Question

Kippure Lodge and Holiday Village,
Kippure Estate, Manor Kilbride,
Blessington, County Wicklow.

Wicklow County Council

EX53/2024

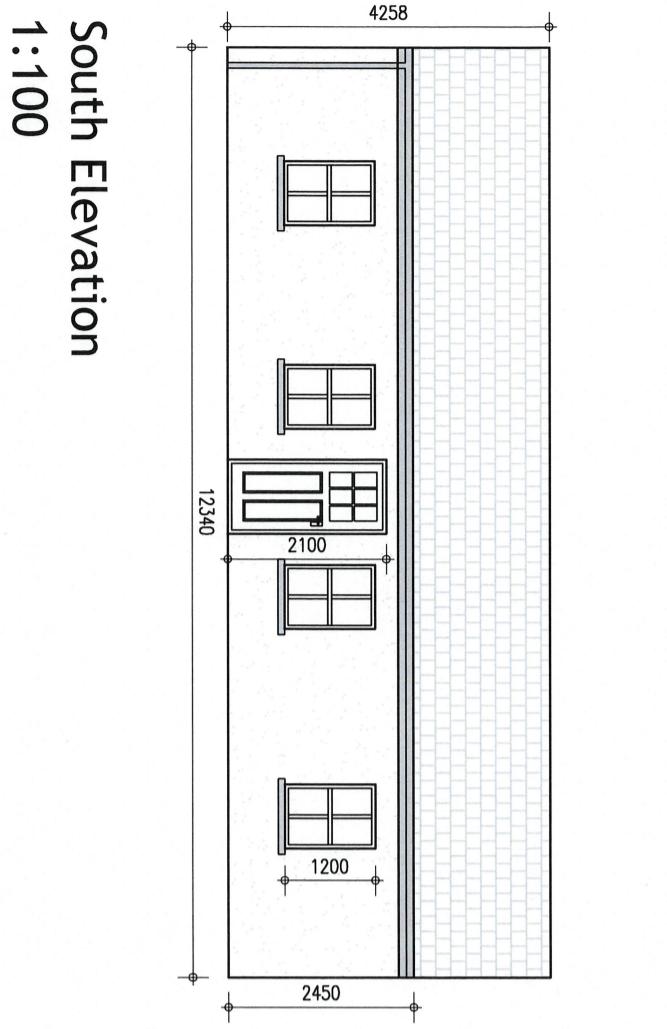
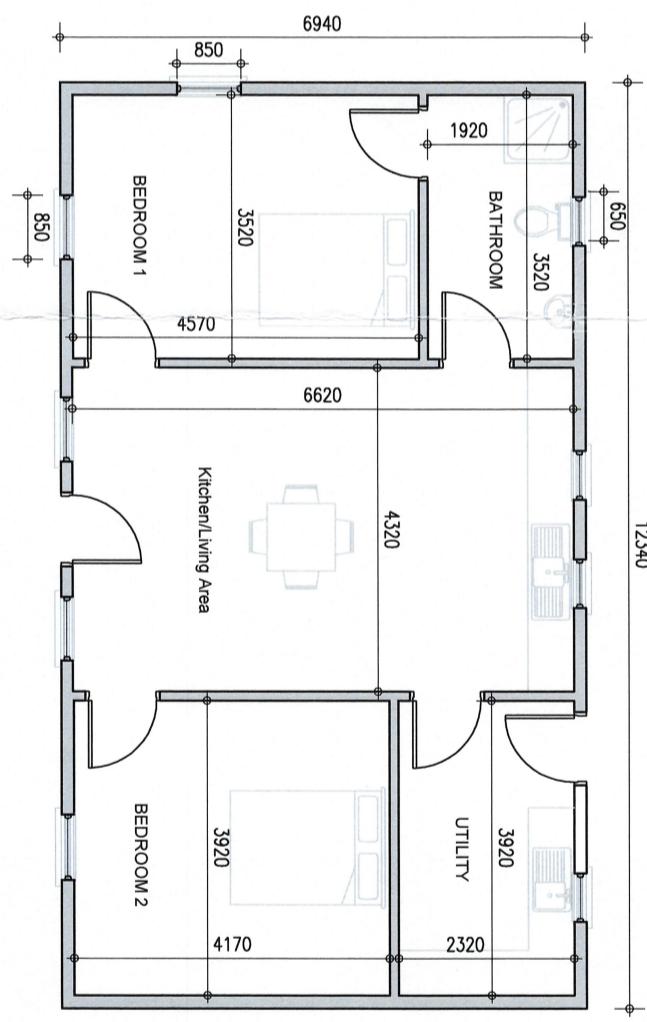
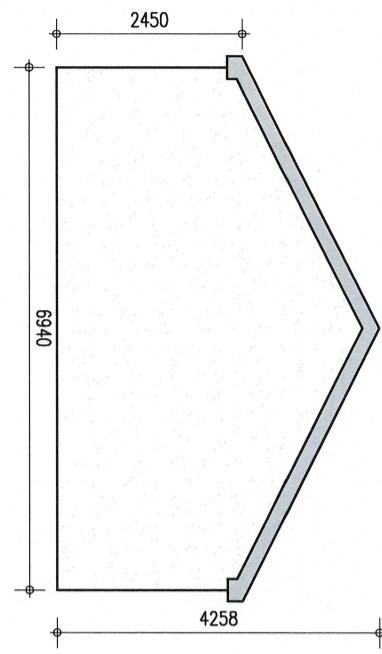
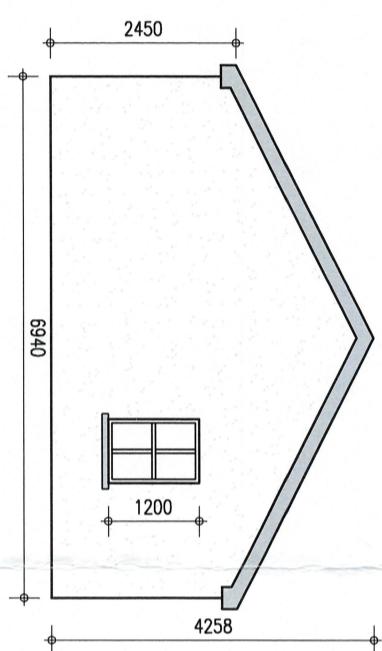
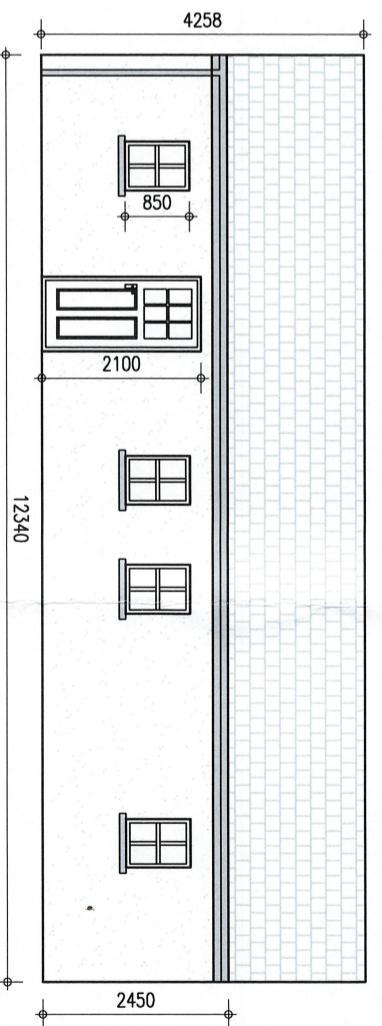
The construction of the gate lodge units would come within the meaning of works and would therefore come within the meaning of development as provided for in Section 3(1) of the PDA.

The provisions of Section 4(1)(h) are not applicable as these are new structures on the land.

The exemption under Class 17 of Part 1 of Schedule 2 is for on-site accommodation for persons who are engaged in the development. The lodges are not for security for the construction works, but security for those occupying the facility. It is not evident that the on-going development has the necessary permissions or exemption, and therefore these lodges do not come within the description of Class 17.

There are no other exemptions available. Therefore, these structures are development and are not exempted development.
